14/4-D012B
590783
Blad/Hydrology
AGREEMENT AND COVENANT

Re: Certification Submittal for Final Building Certificate of Occupancy for
Maloy Office Bldg, Lot 1B1, Unit 2, [M-14 / D12B]
610 San Jose SE
Architect's Stamp Dated 04/04/06

**Re: Maloy Office Building, 610 San Jose SE,
Approval of Permanent Certificate of Occupancy, (M-14/D012B)
Engineer's Stamp Date: 12-19-03
Certification Stamp Date: 3-17-09**

**Re: Maloy Construction Building Addition, 610 San Jose SE, Traffic
Circulation Layout**
Architect's Stamp dated 7-12-04 (M14-D12B)

DATE: 02/04/04 REV: 01/01/04 REV: 01/14/04 REV:
MALOY CONSTRUCTION, INC.
BUILDING ADDITION
410 SAN JOSE SE ALBUQUERQUE, NEW MEXICO
WILLIAM KLEINSCHMIDT : ARCHITECT
2820 BLUE RIDGE PLACE NE ALBUQUERQUE, NEW MEXICO 87111 505-761-0000

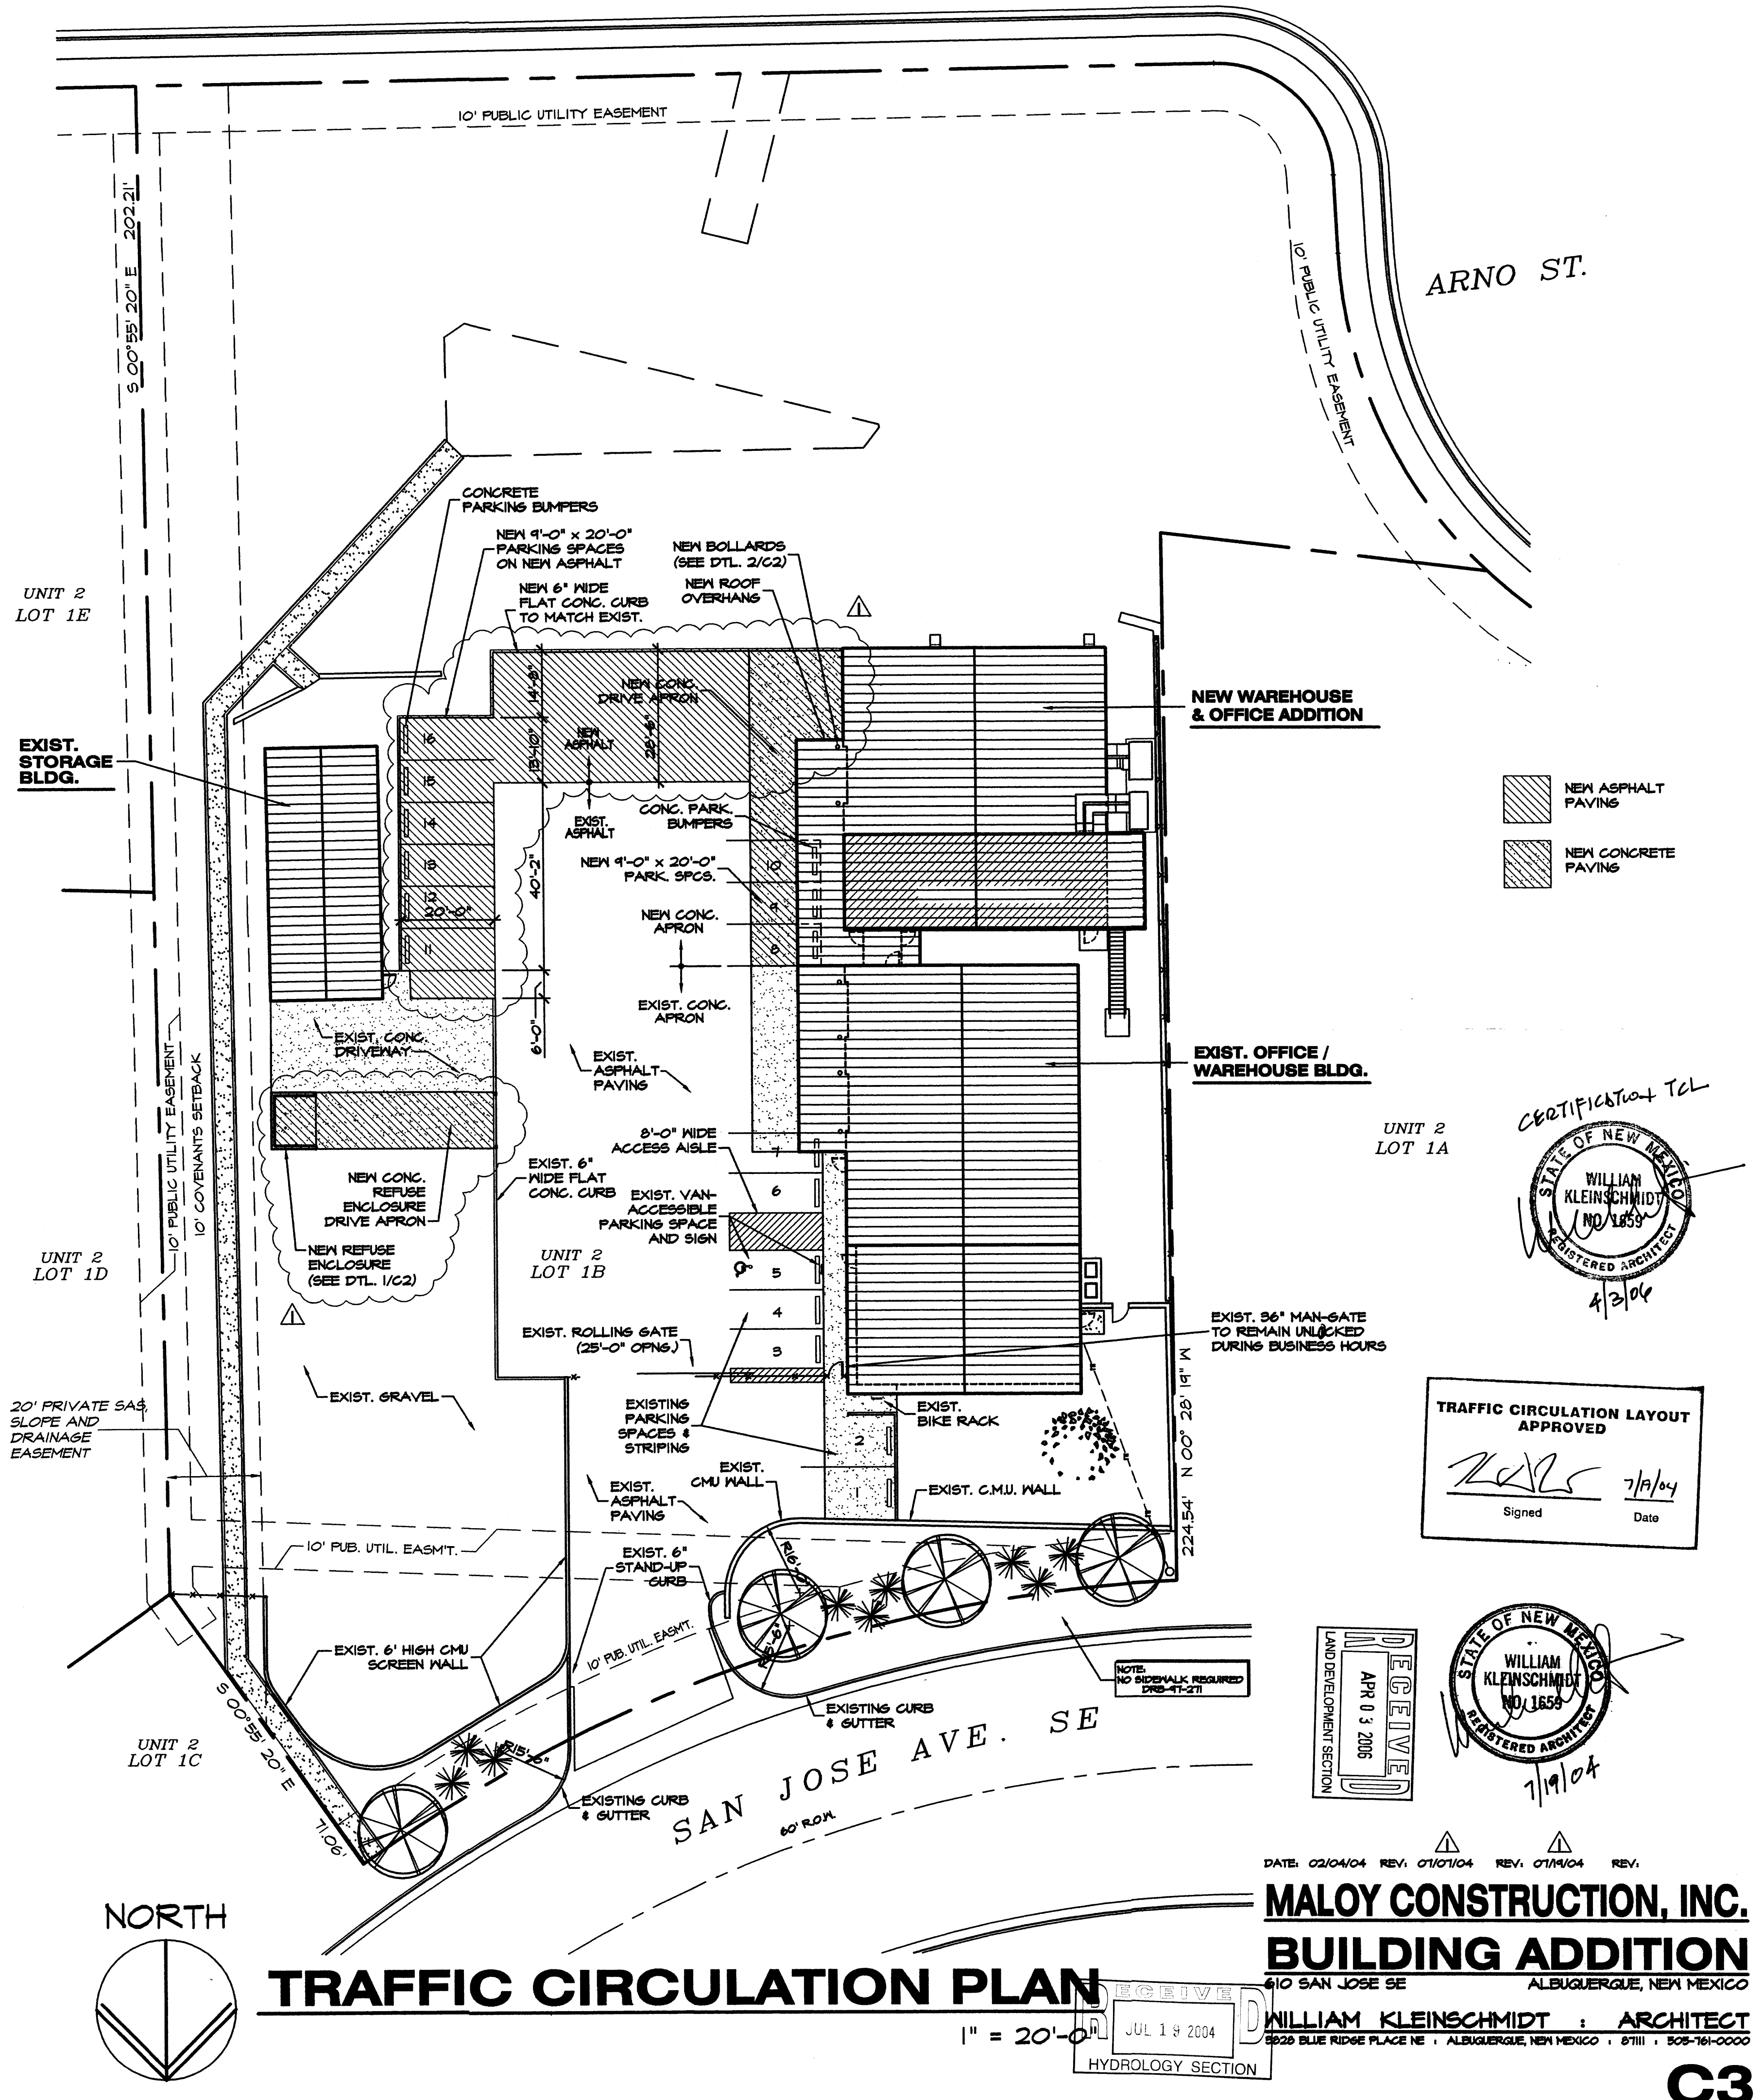
1. List radii for all curves shown.
2. What is the width of the access aisle adjacent to the handicapped parking space?
3. Please show a vicinity map.
4. The parking spaces must be paved.
